## **Flood Management Consultation**

**Consultation on Application Number: 2015/62/90435/E**

**Address: Parkham Foods Ltd, 22, Halifax Road, Millbridge, Liversedge, WF15 6JQ**

**Proposal: Erection of 14 dwellings with integral garages**

Client: Lakeland Properties	
Project: Former Parkam Foods Site Residential Development	
Drawing: Existing Site Survey	
Date: Feb 2015	Scale: 1:500@A3
Drawing No: 1434/101	Rev:

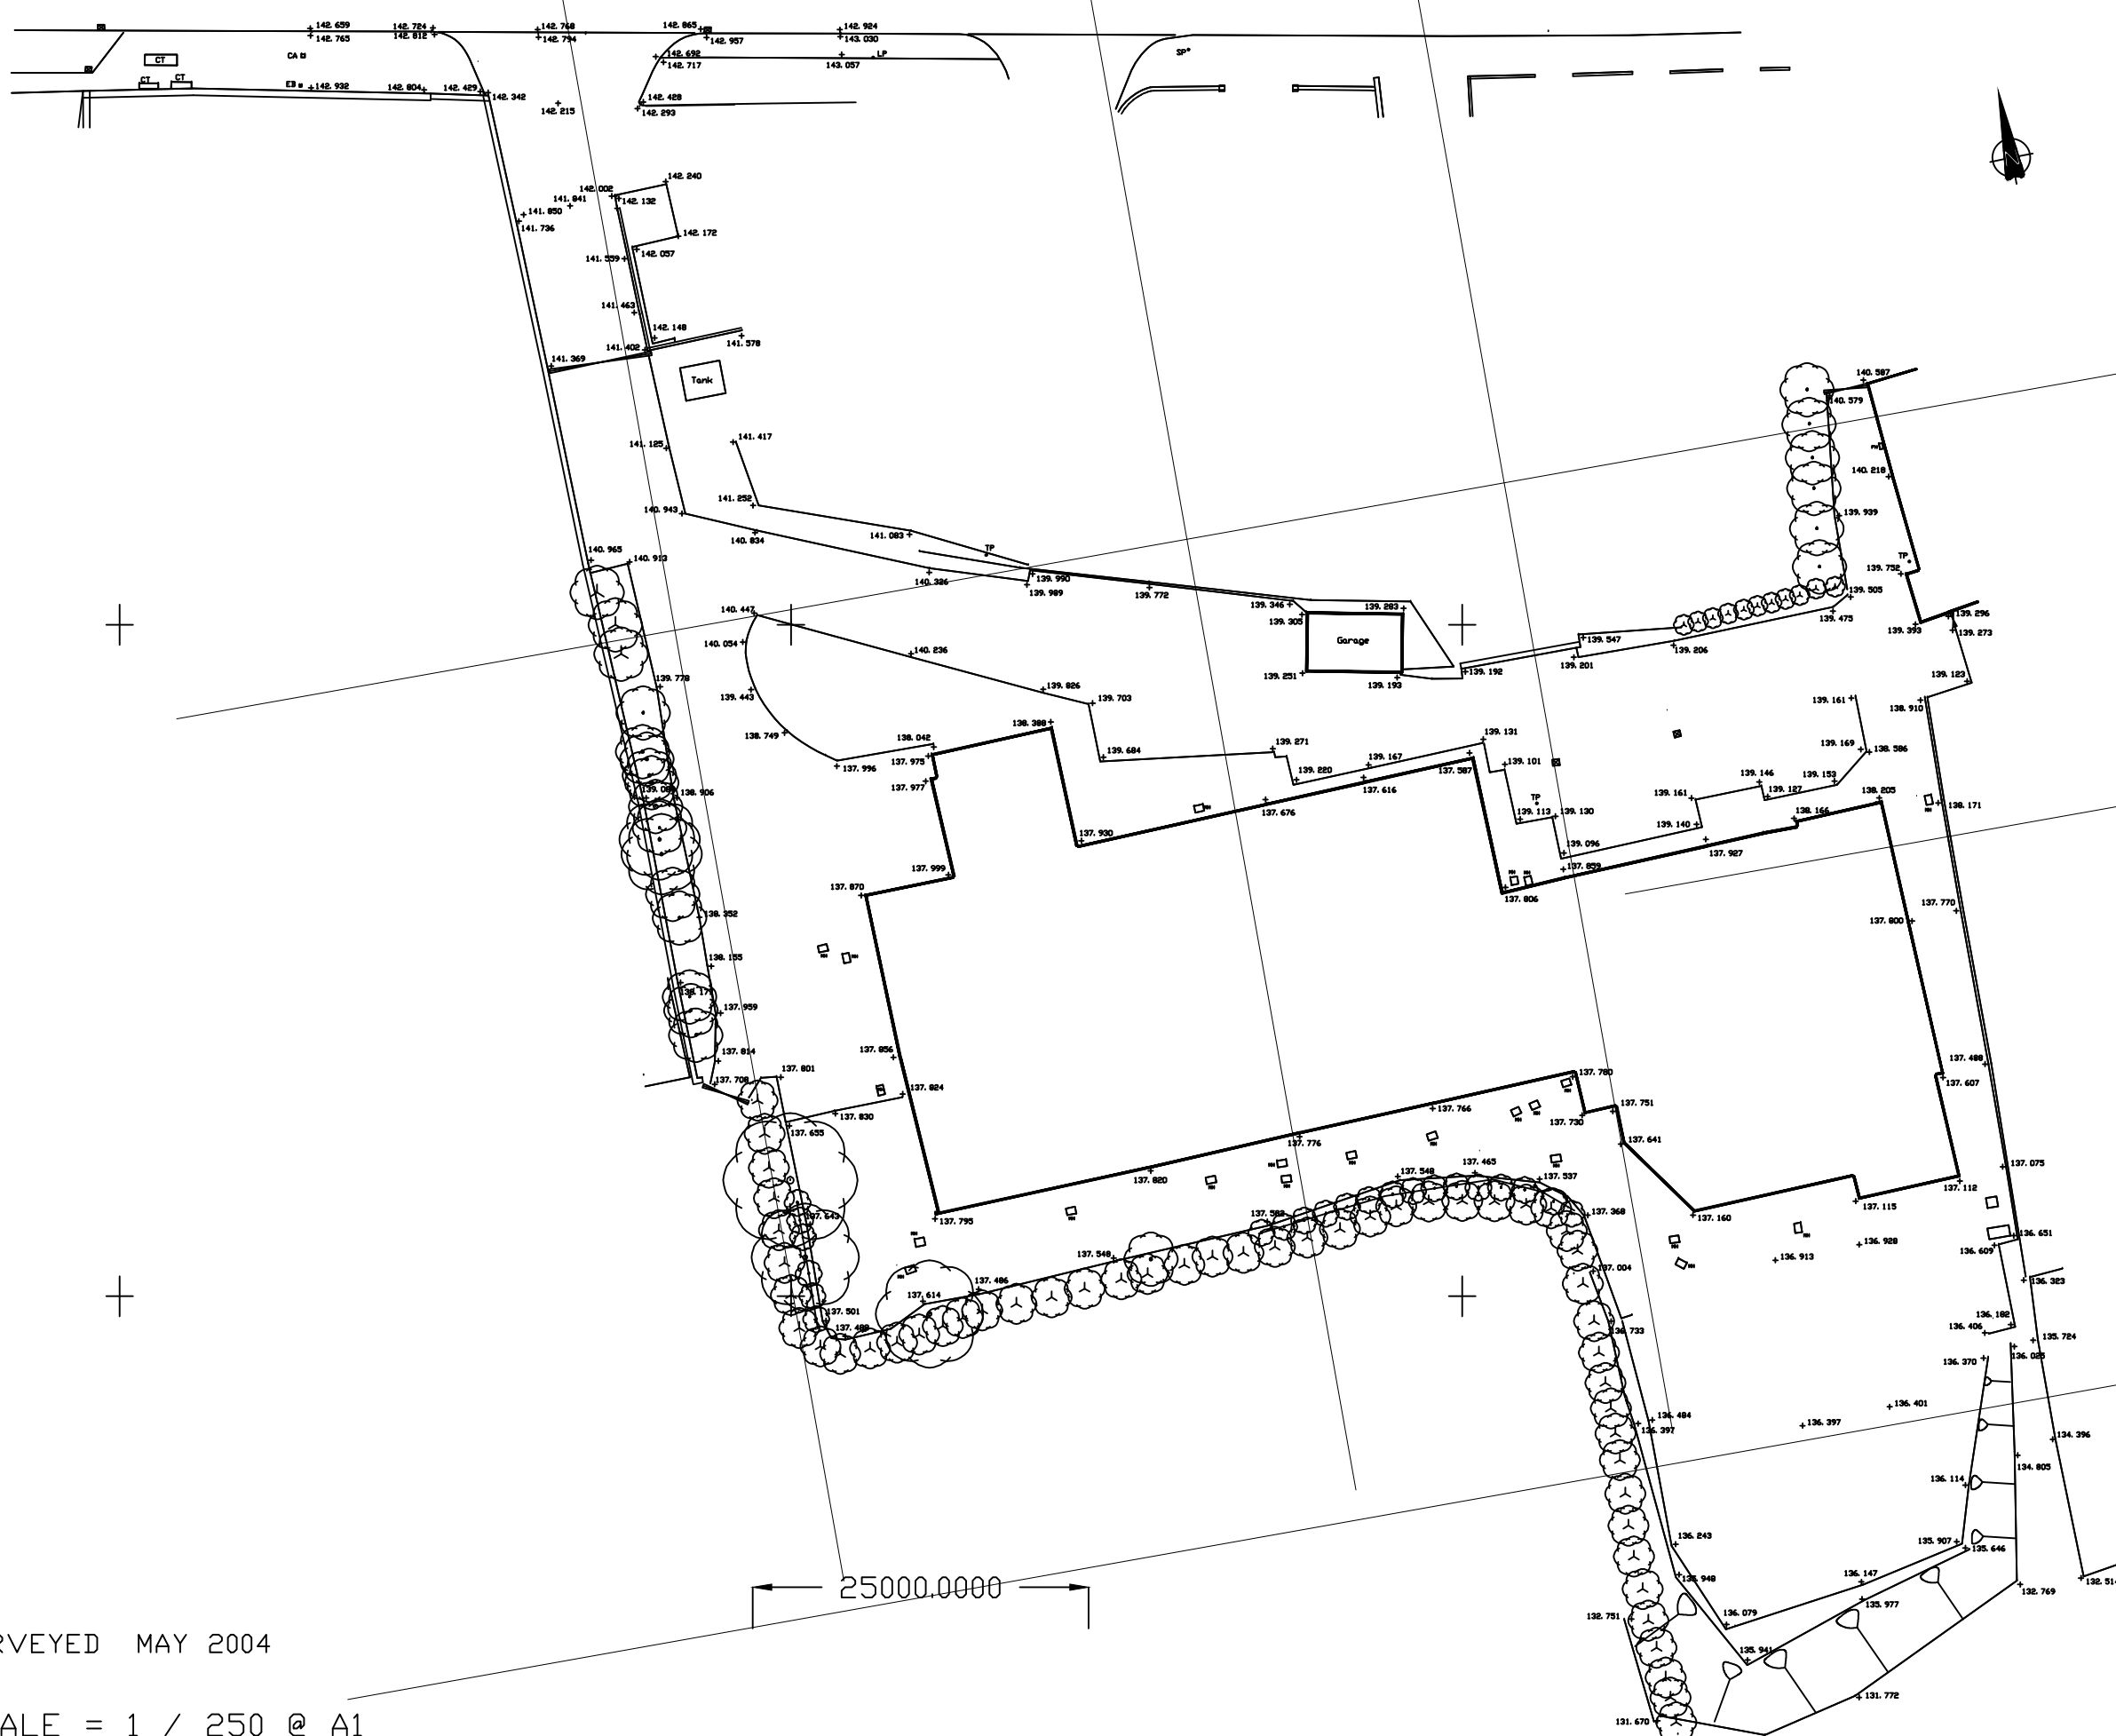
**The site falls away from Halifax Road and so connection to the existing public sewer here might not be possible via gravity.**
